SUNNICA ENERGY FARM
REF: EN01016 DRAFT DEVELOPMENT CONSENT ORDER
PLANNING ACT 2008
INFRASTRUCTURE PLANNING (APPLICATIONS: PRESCRIBED FORMS
AND PROCEDURE) REGULATIONS 2009

WRITTEN SUMMARY OF ORAL CASE FOR EAST CAMBRIDGESHIRE
DISTRICT COUNCIL & CAMBRIDGESHIRE COUNTY COUNCIL

ISSUE SPECIFIC HEARING 4

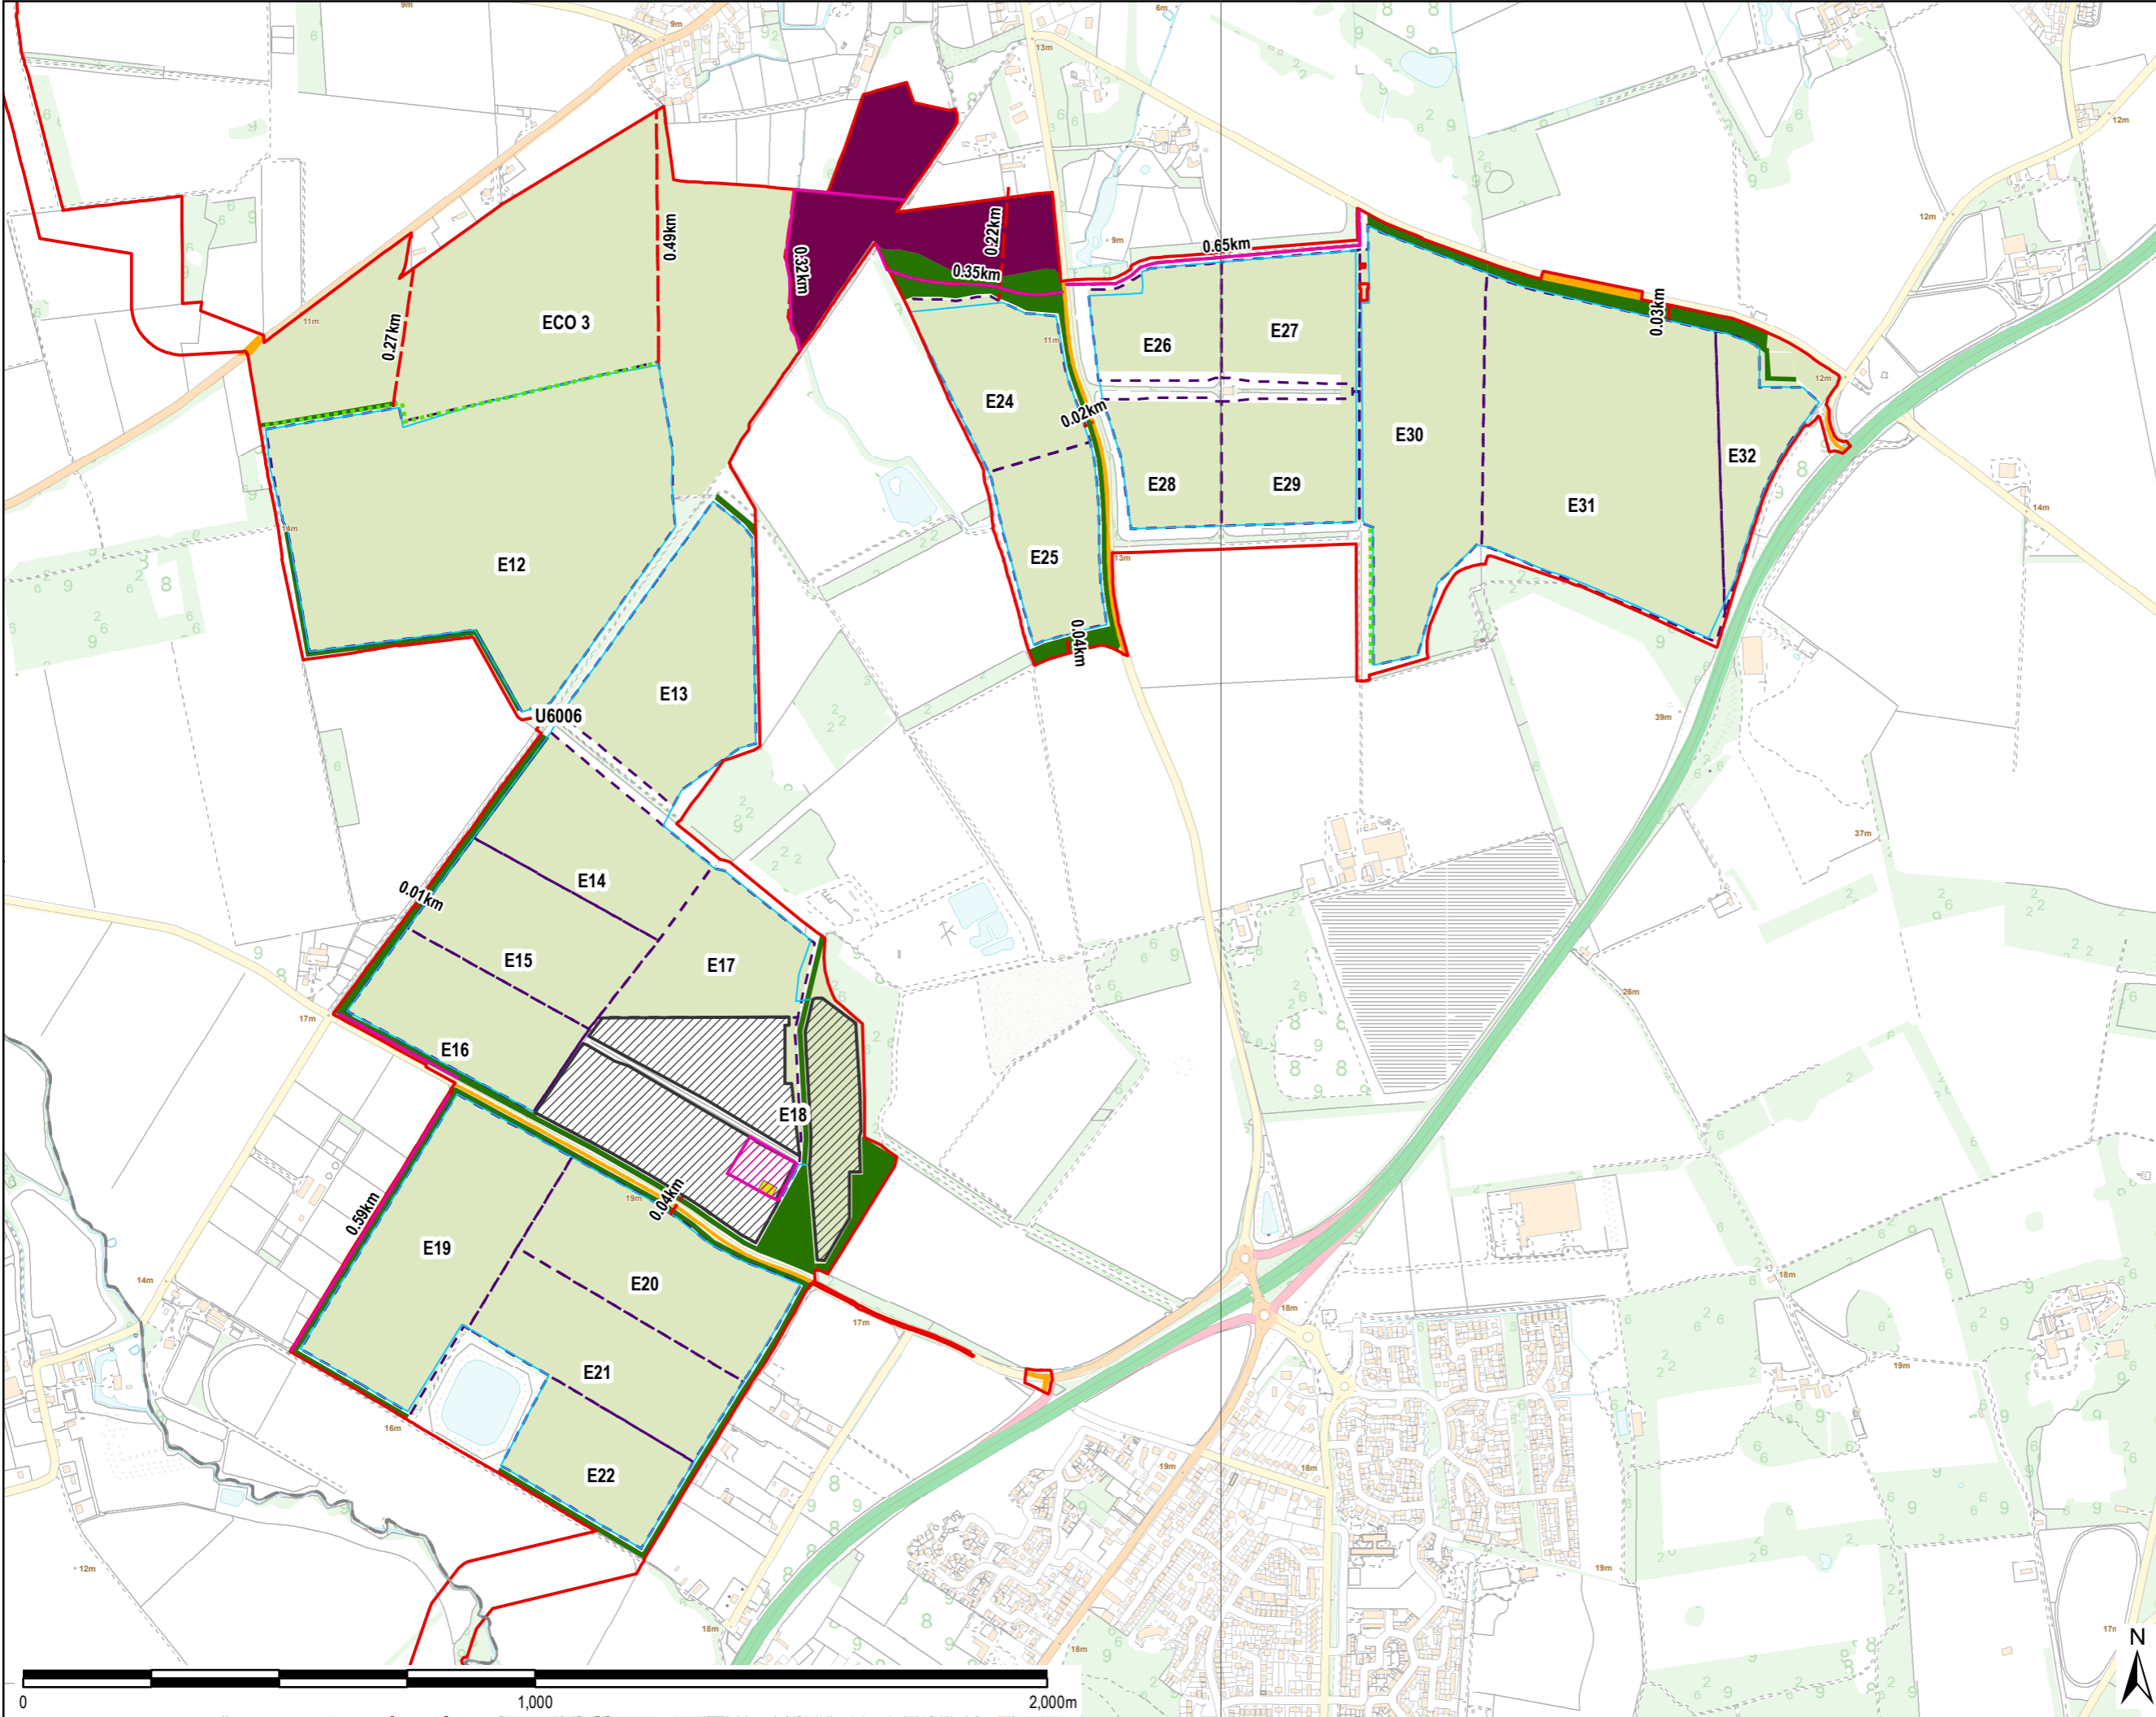
12. ECDC remain concerned around the impact on The Avenue (Chippenham Park Registered Park & Garden) as well as the plane crash site, parcel E05.
13. To this end, the following is added in relation to these elements. Without prejudice to the Council's view that **parcel E05** ought to be removed completely and the landscape being very open with far reaching views presents a challenging starting point from which to seek appropriate mitigation.³ It is the Councils' view, that Lee Brook would provide a more natural boundary to the scheme in the west. Without prejudice, the Councils have responded the ExQ2 with regards to reduction of E05 to an existing field boundary, which would leave the Plane Crash site outside the solar development and would allow a much more open landscape, appropriate to this area. However, should Parcel E05 be retained in its entirety, there is a real

- (i) The raising of the viewing area of the crash site for better vantage points;
- (ii) To provide interpretation signage to explain the history of the plane crash site to the general public;
- (iii) To remove solar panels along the assumed flight path in a V-shape; creating a visual link from Beck Road/the permissive footpaths across the crash site towards Mildenhall;
- (iv) Allow access to the crash site area; provide seating for contemplation wherever appropriate;
- (v) Work with the community of Isleham to commission a commemorative sculpture.

21. Specifically in relation to **E05**, there remains the conflicting requirements for landscape public amenity / recreation, historic environment and ecology issues. In applying the mitigation hierarchy to *avoid harm*, it is the Council's view that E05

Drawing Title
**FIGURE 10-14E
LANDSCAPE MASTERPLAN
SUNNICA WEST SITE B**

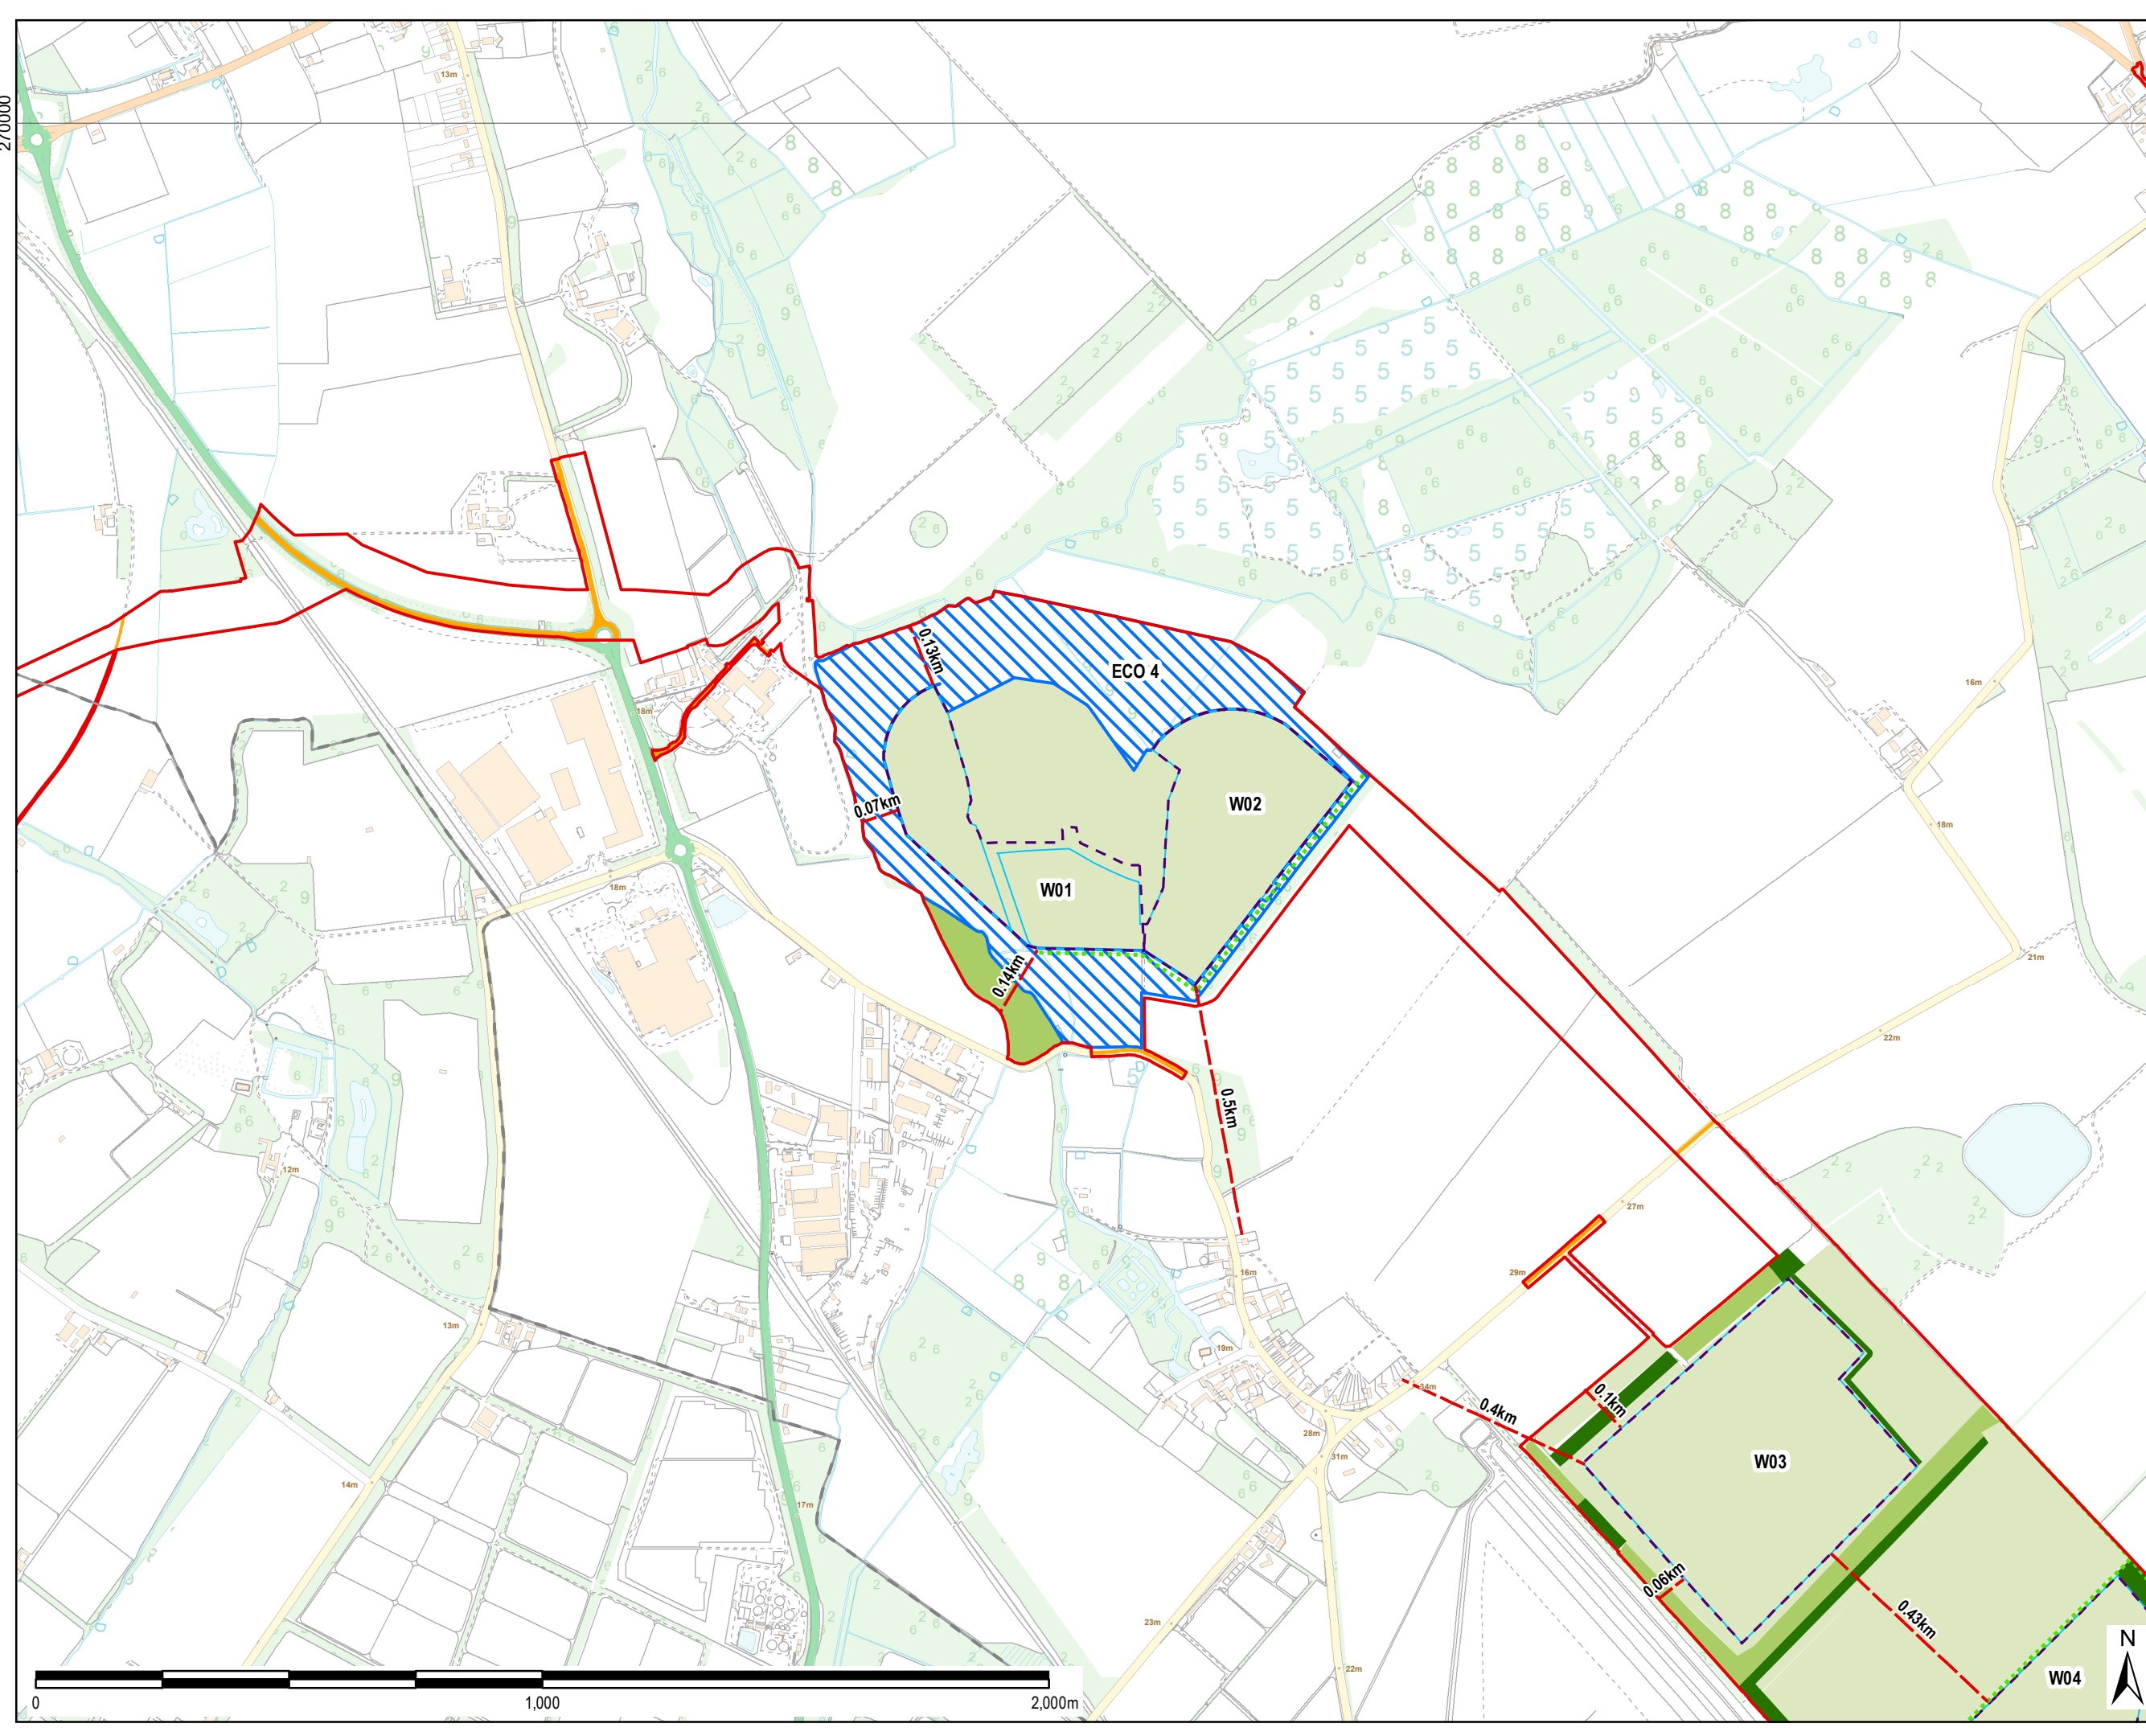
10. It is the Council's view that it would not be possible to achieve effective mitigation in relation to the following parcels: **W04, W05, W07, W08, W09, W10, W11, W12, W17**. As explained, the mitigation itself – in the form of intrusive visual screening, would be detrimental to this historic landscape.²
11. Notwithstanding this position, the Councils have produced, in response to the ExA's Action Point 1 of ISH4, a table which details parcel by parcel residual landscape impacts and potential further mitigation.

20. In so far as parcels **W03, W04, W05, W06, W07, W08, W09, W10, W11, W12, W17 and ECO5**, the Council's view remains unchanged, notwithstanding what the Applicant has provided by way of a response.⁵ In short, the requirements for visual screening remain irreconcilable with constraints within the historic landscape around Chippenham Park RPG. Notwithstanding this position, the Councils have produced, in response to the ExA's Action Point 1 of ISH4, a table which details parcel by parcel residual landscape impacts and potential further mitigation. ECDC supports and agrees with the further detailed comments put forward by SCC in the Deadline 6 submissions.
